Recommendation Report for Planning Permission

REF NO: LU/119/25/PL

LOCATION: Unit 11a To Unit 11d
Lineside Way
Littlehampton
BN17 7EH

PROPOSAL: Extension of industrial unit and installation of new palisade fencing gates to adjoin existing dropped kerb (resubmission following LU/303/24/PL). This application is in CIL Zone 4 (Zero Rated) as other development.

Drawing:
Proposed Drainage Strategy

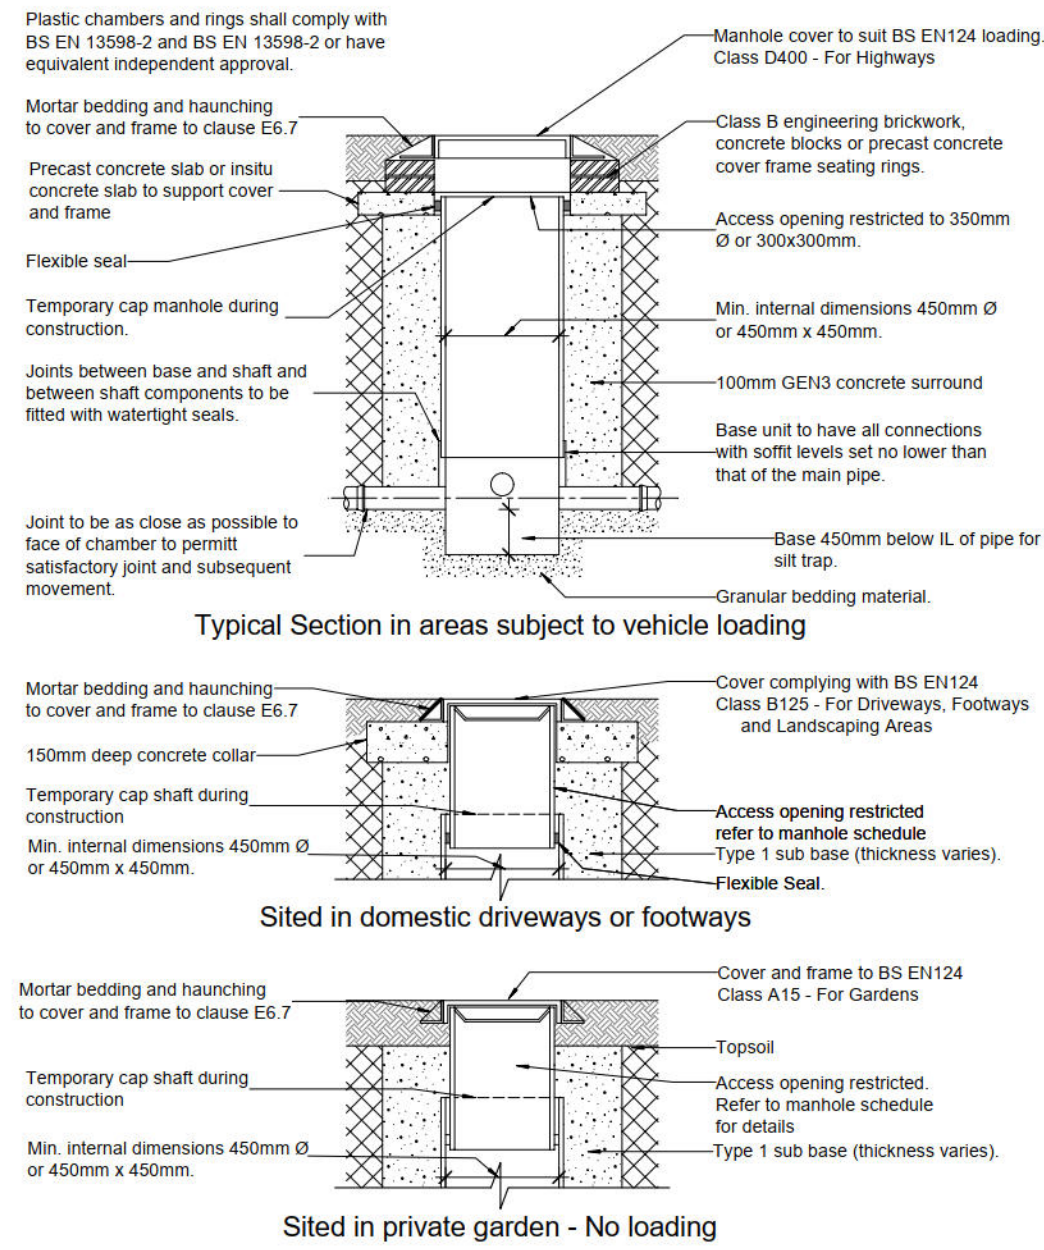
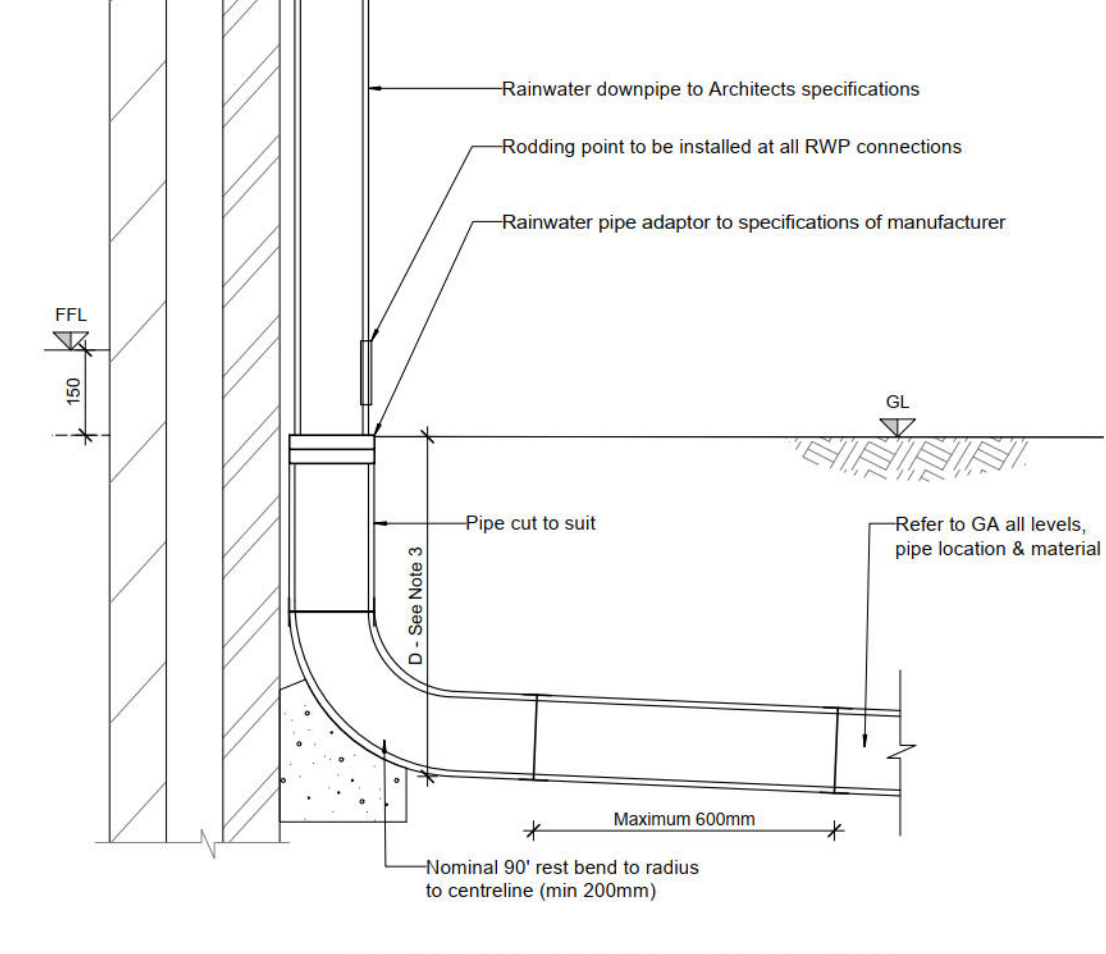
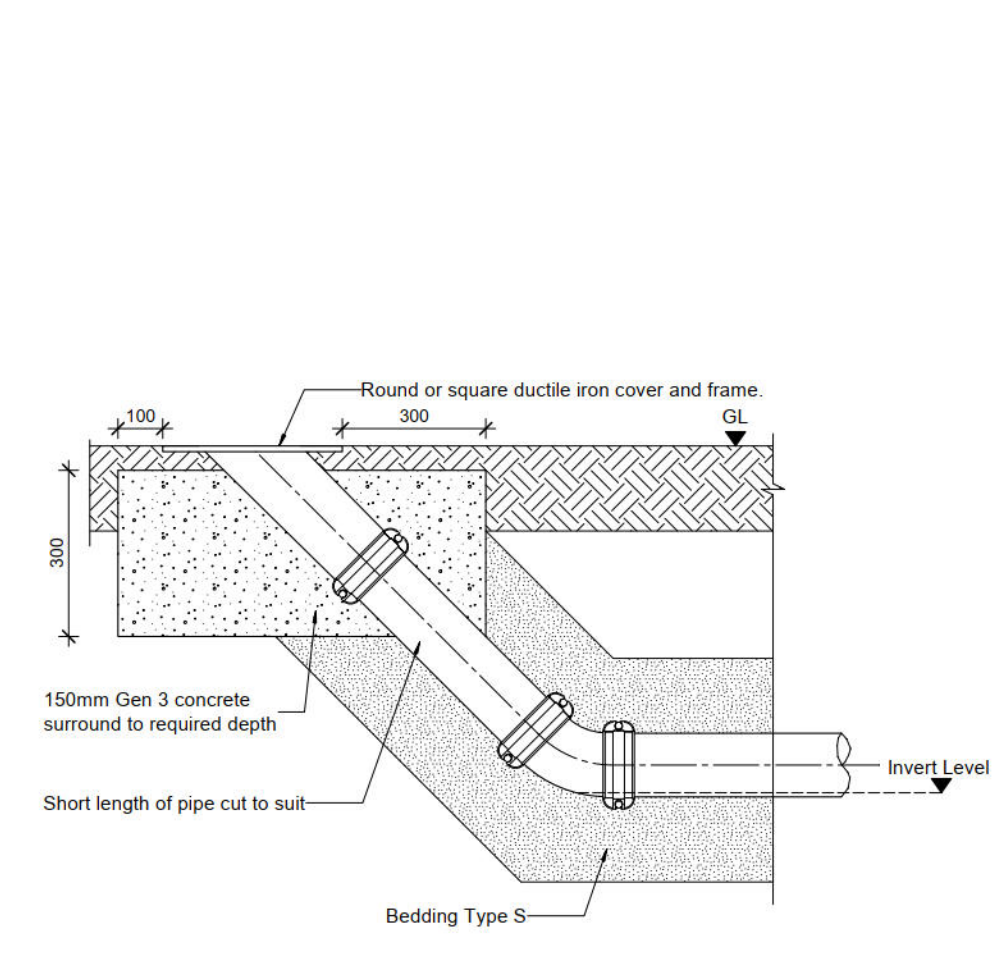
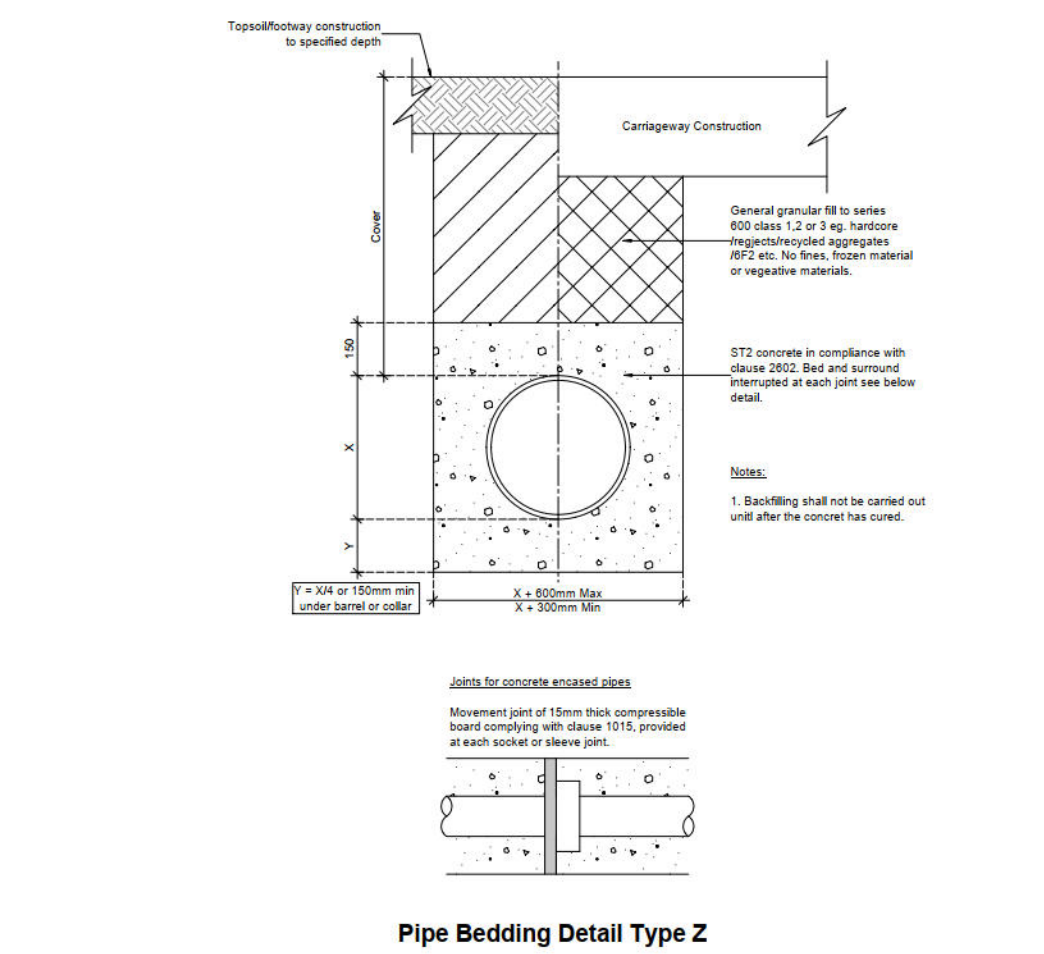
- The existing gravity surface water sewer crossing the site is to be diverted. Insufficient detail and evidence has been provided to show the diversion is feasible and Southern Water and Network Rail should be consulted on this matter.

- The diversion may impact the deliverability of the proposal and its SUDS design given the proposal seeks to discharge to this sewer. It has, therefore, not been demonstrated that a viable disposal location has been identified.

- The proposal seeks to incorporate planters for interception drainage, but no assessment of this has been provided to show compliance with the requirements of the NSfS.

- The proposed peak discharge rate is over 5 times greater than the greenfield runoff rate, more than the maximum relaxation factor outlined in the NSfS and it is unjustified when alternative products that would allow a reduced rate are available.

- Onsite levels and exceedance paths are not shown.
- It is unclear if there are necessary easements to the railway line and whether the proposed surface water drainage would conflict with them. The sewer diversion is not likely to be permitted within the railway embankment and designs should be provided and Network Rail consulted at the planning stage to review this.

Concerns have been raised in relation to the existing gravity sewer for surface water that is anticipated to run through the site and have a large diameter of 675mm based on Southern Water mapping/data. Should the position and diameter of the sewer prove accurate to the data available, the proposal would not likely be able to build over this sewer. As a result, it would need to be diverted, and a diversion has been proposed. No detailed evidence of the potential diversion has been provided beyond Dwg N. 003 P2 which shows a new route for the existing sewer that avoids the extension and relocates manhole point 8751 (point of connection). The diversion appears to show the sewer moving off site into the

boundary of the railway line embankment to the west. The ADC Engineers are not satisfied with the level of detail provided in respects of this diversion as it has not been confirmed as viable or agreeable with relevant third parties. Southern Water and Network Rail were consulted on this application originally (prior to the proposed diversion), but this was prior to the proposal seeking to divert the surface water sewer to which it seeks to connect offsite and within the railway boundary, as such, no comment in respect of the viability/agreeability of this diversion has been received from these parties. In any event, the proposed diversion has not been confirmed as viable or agreeable and has been supported by minimal detail. While separate legislative processes exist for the building over/diversion of a public sewer under Sections 159 and 185 of the Water Industry Act 1991, as the proposed connection point to the surface water sewer may require relocation as a result of the diversion, it is unclear that the sewer (and the proposed point of connection) could be relocated while ensuring the point of connection for the proposed drainage design is viable. Southern Water have confirmed that the sewer would have sufficient capacity to accommodate the proposals, but until the finalised location of the surface water sewer has been confirmed, it cannot be assumed that the currently proposed point of connection would be viable. As such, the point of connection to the disposal location is unconfirmed and whether it would be viable following the diversion is speculative.

No assessment of the proposed interception measures (planters) against the NSfS has been provided. As a result, it cannot be confirmed that the interception drainage requirements of the NSfS have been met.

The ADC Engineers have identified that no assessment of the impacts of surface water flooding has been provided within the submitted Flood Risk Assessment, and that the ability of the drainage system to function under flooded conditions and with a surcharged outfall has also not been demonstrated. The proposed discharge rate (0.7l/s) is also over five times greater than the greenfield runoff rate, and much greater than the maximum relaxation factor suggested by the NSfS. It appears to have been selected based upon the flow control product of choice, but alternative products are available that would reduce this rate to below 0.5l/s. Proposed onsite levels and exceedance paths are also not shown on the drainage layout.
